CITY OF ALBUQUERQUE

**RE: 4838 Guadalupe Trail NW
Grading & Drainage Plan
Engineer's Stamp Date: 1/20/24
Hydrology File: F14D087
Case # HYDR-2025-00033**

ENGINEER'S SEAL 	LOT 1A LANDS OF FRANK L. SPRING 4838 GUADALUPE TRAIL	DRAWN BY DEM
	GRADING AND DRAINAGE PLAN	DATE 1-18-25
		4838 Guadalupe Tr. dwg
		SHEET # C1
DAVID SOULE P.E. #14522		JOB #

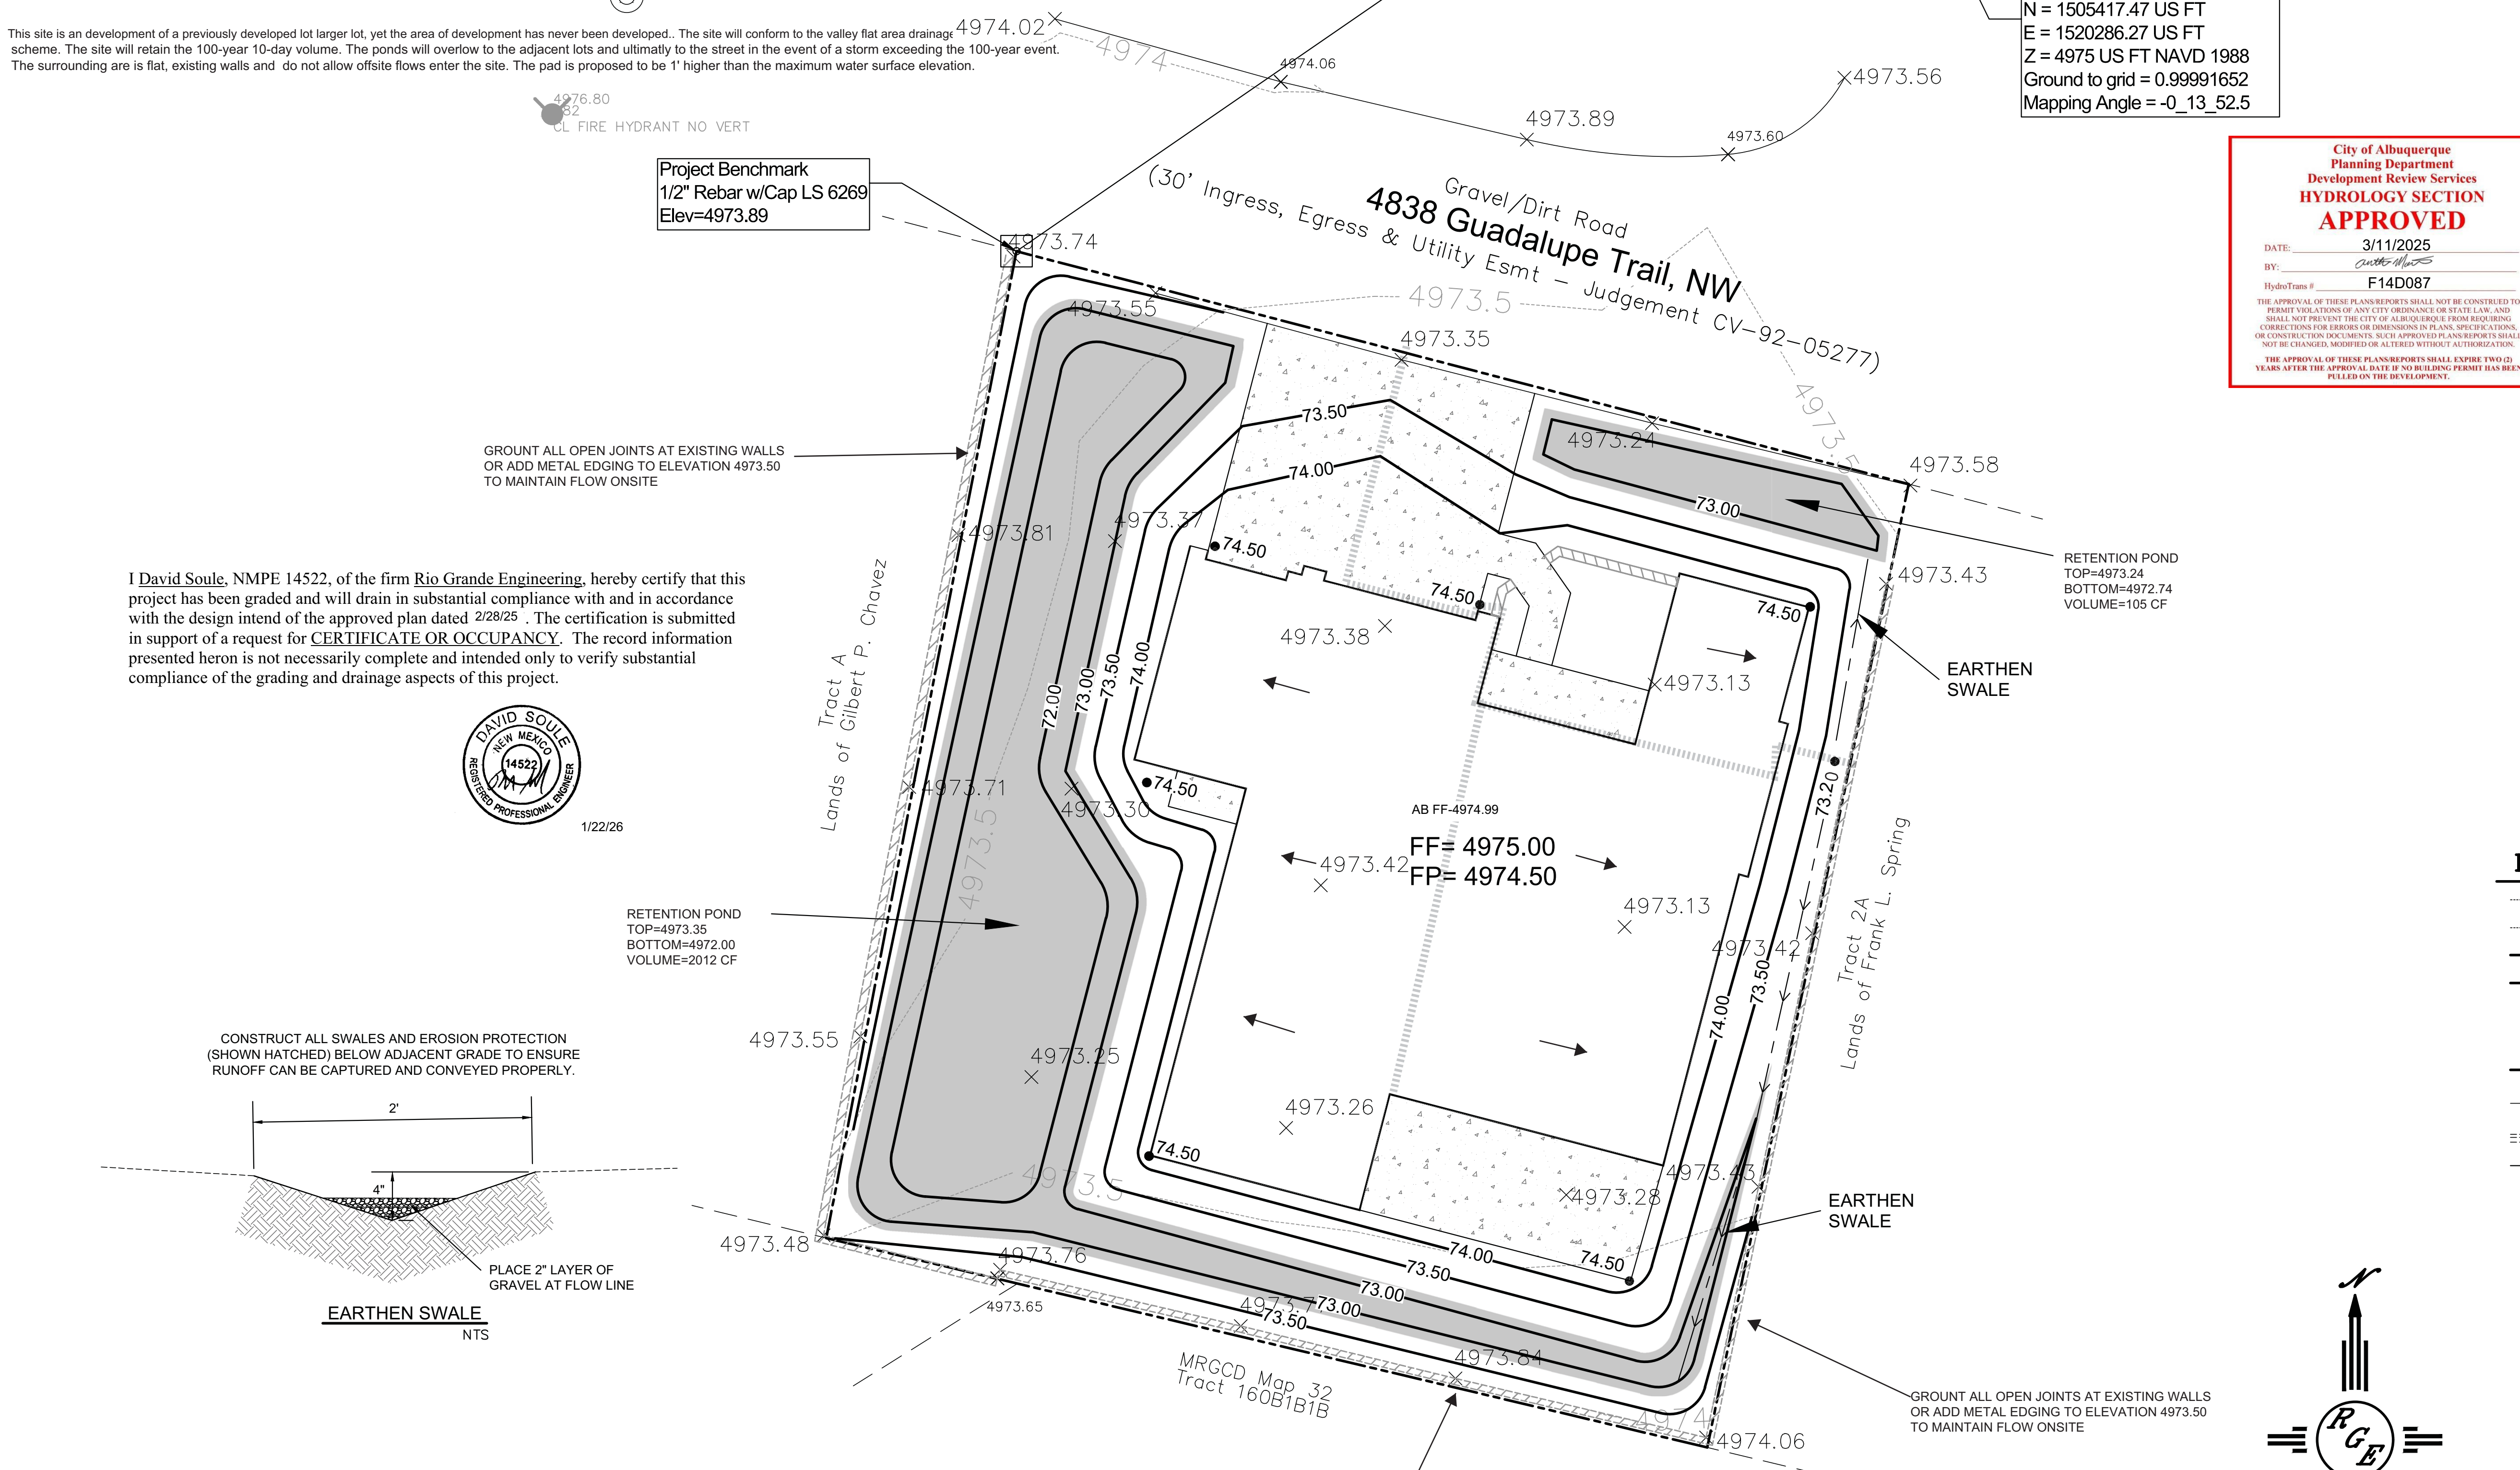
1. The narrative states that the site will conform to DPM section 6-5(A). Please describe the method that will be used for the water harvesting goal of capturing ½" of runoff from impervious areas on the site.

2. Please show the roof flows on the plan.
3. DPM Part 6-5(A) No. 3 recommends that the finished pad elevation is to be a minimum of 18 inches above the edge of pavement or roadway. The FP of 4974.50 is less than 12 inches at the corners. Part 6-5(D) allows for the FP elevation to be a minimum of 1 foot above the 100-year 10-day stormwater surface elevation, however the 100-year 10-day stormwater surface elevation was not documented in the plan. The narrative states that the pad is proposed to be 1.15' higher than the maximum water surface elevation. This seems to be the difference from the FP and the low point at the roadway in front of the driveway. This would imply that the roadway elevation is the same as the 100-year 10-day stormwater surface elevation. Please review and adjust accordingly.

4. Per DPM Part 6-5(D) - A permanent perimeter wall or barrier around the development is required to contain the 100 year 24 hour storm developed runoff. Runoff to adjacent properties will not be allowed.
5. Please show the required SWQV calculations for this site. To calculate the required SWQV, multiply the impervious area draining to the BMP by 0.42 inches for new development sites.
